WALBERTON PARISH COUNCIL

**Planning Application WA/61/09T – Cedar Cottage, Wandleys Lane
Reduction of Oak tree by 45%**

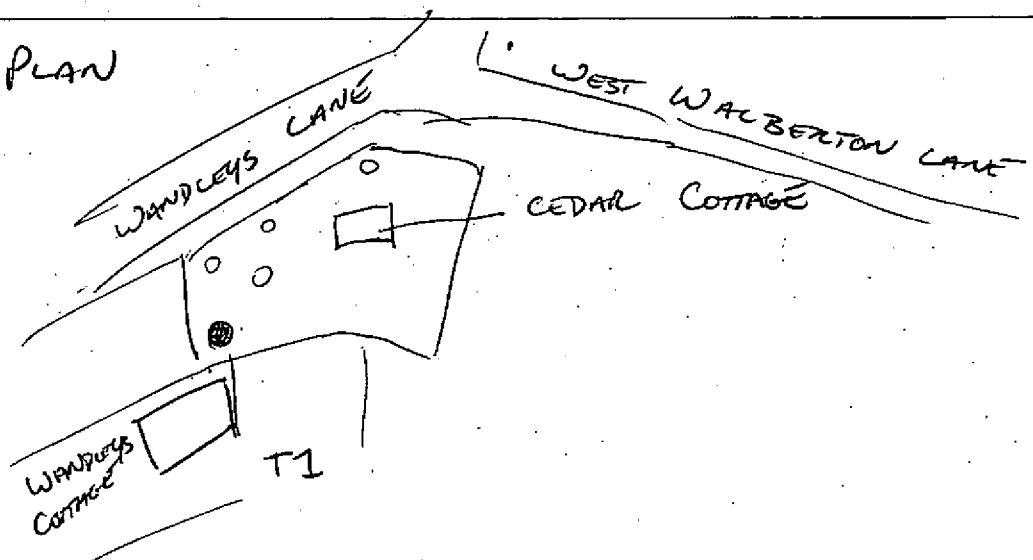
It is difficult to know which 45% they want to take off - lower branches, top, or all over but it is a major change and I could see no obvious good reason to do this.

Without a major compelling reason I would say work to this extent should not be allowed. That corner of the parish contains some of its finest trees – nearly all oaks - and the precedent of allowing beheading would not be good policy.
